Objection to proposal for the Demolition of existing chapel and erection of 4 dwellings

Planning Application 15/01540/F

Drawing Title  
**Proposed Layout**  
GROUND FLOOR PLAN

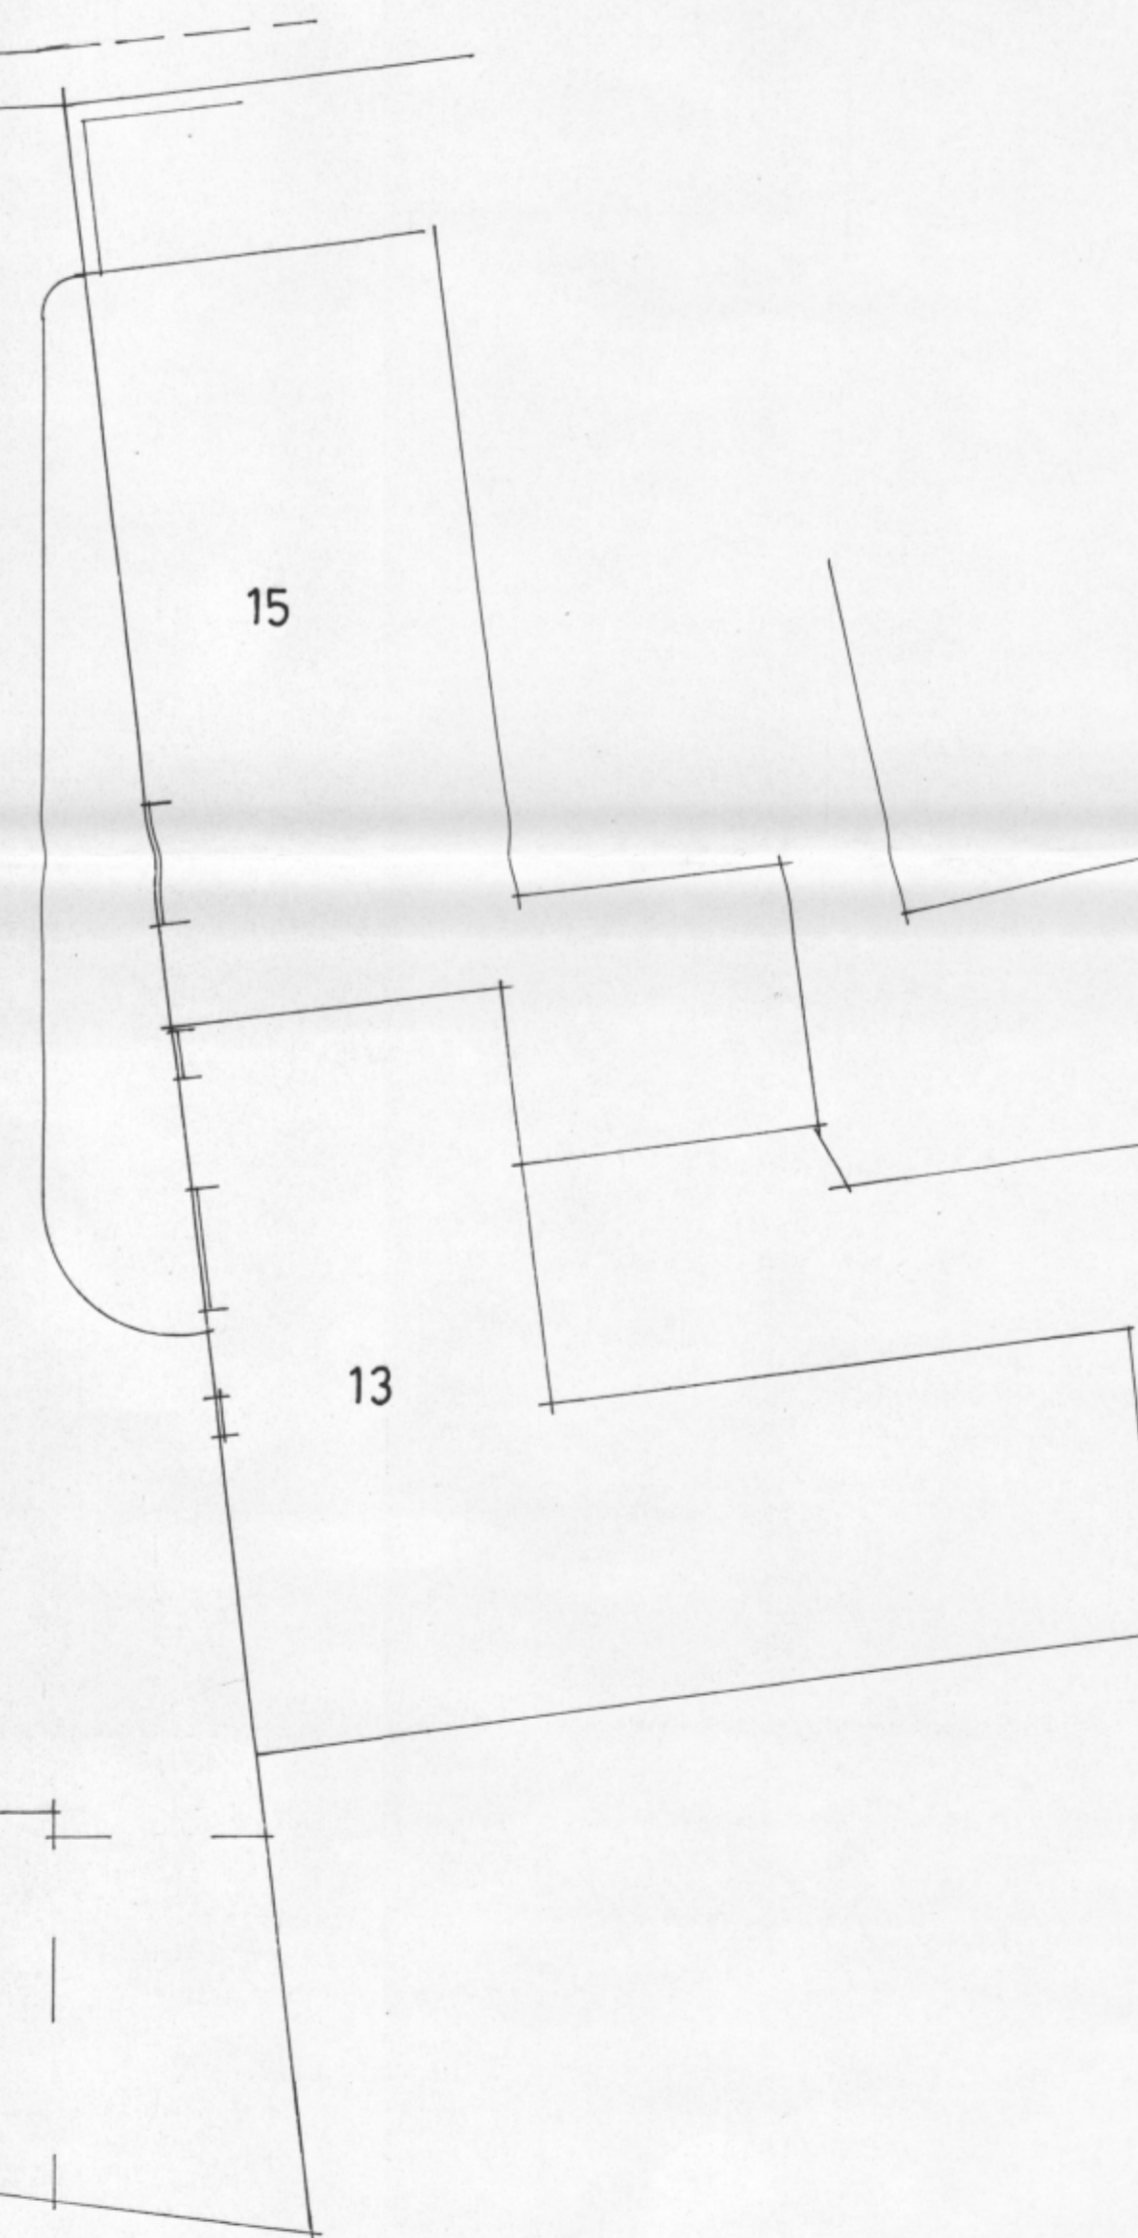
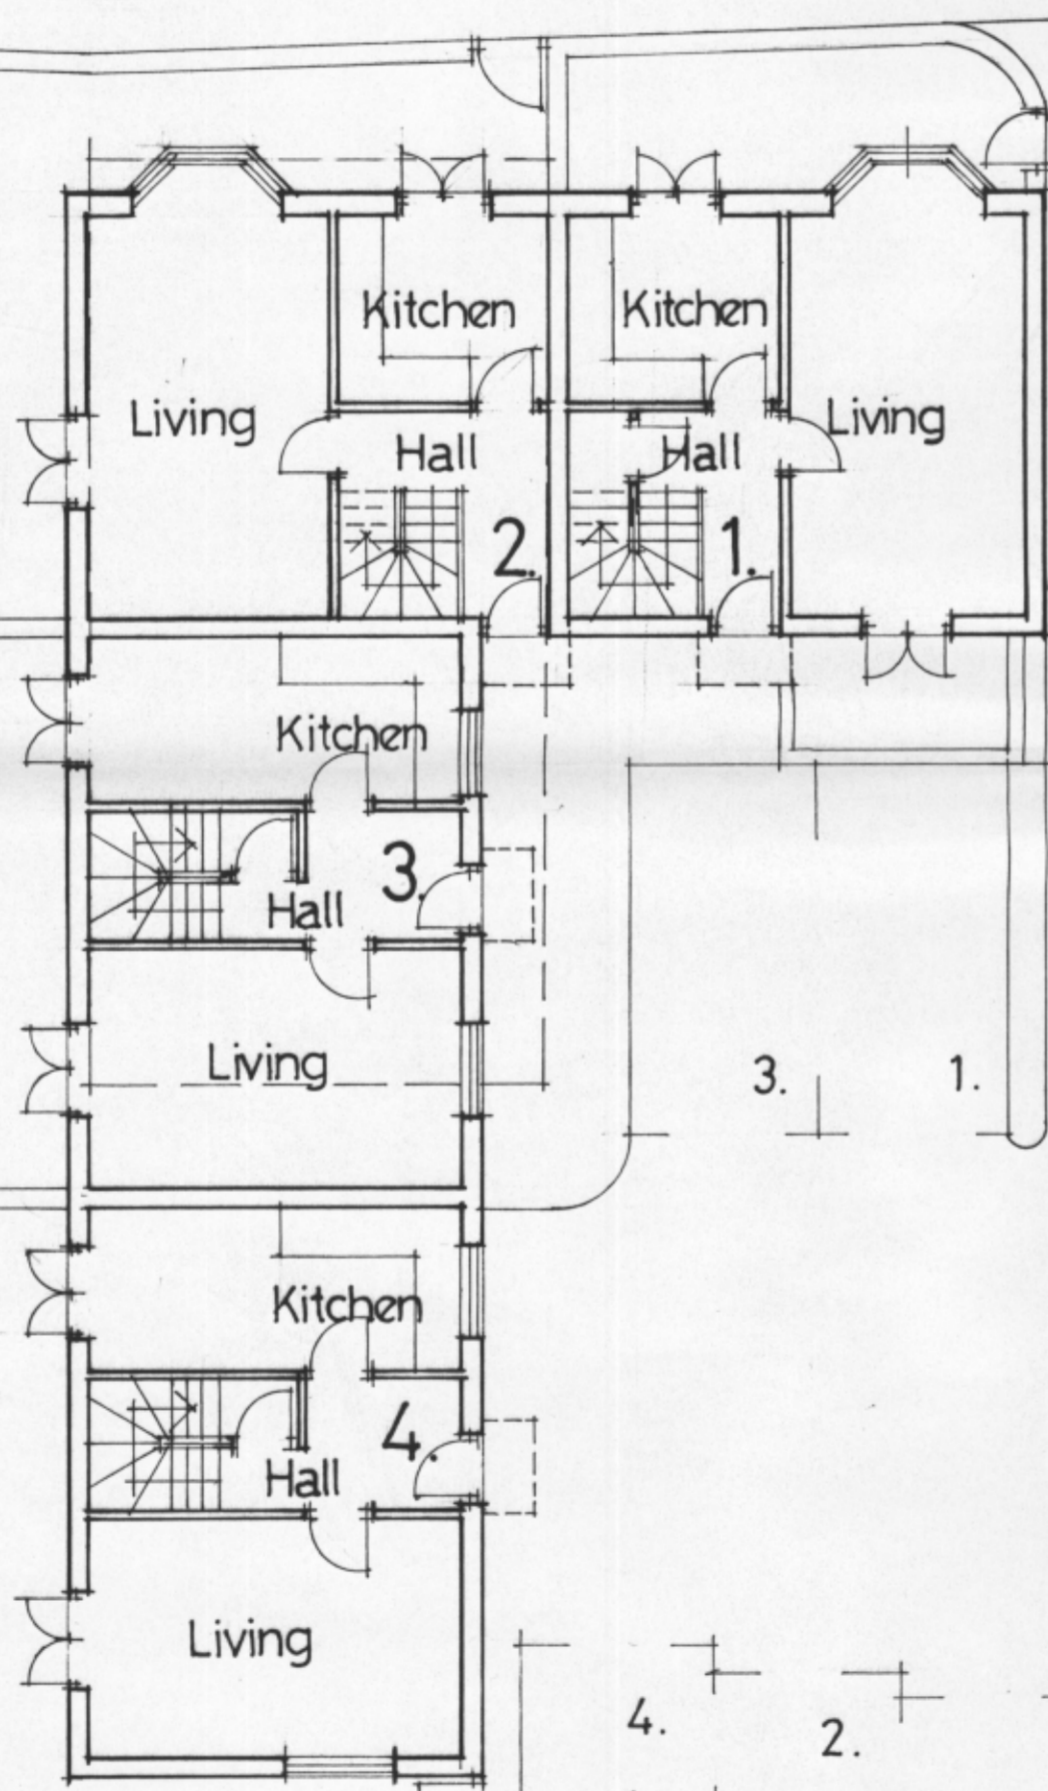
1. The erection of 4 dwellings will lead to over development of a small site having inadequate provision for off road car parking.

2. There appears to be inadequate provision not only for the storage of recycling bins but also for appropriate near road placement on collection days.

3. Egress from the site by cars will be hazardous due the narrow access road provided and limited visibility due to roadside nature of Partridge Court.

If there is inadequate turning facility within the development then reversing onto the road will be likely. Please reference our remarks above about the importance of protecting children and vulnerable adults.
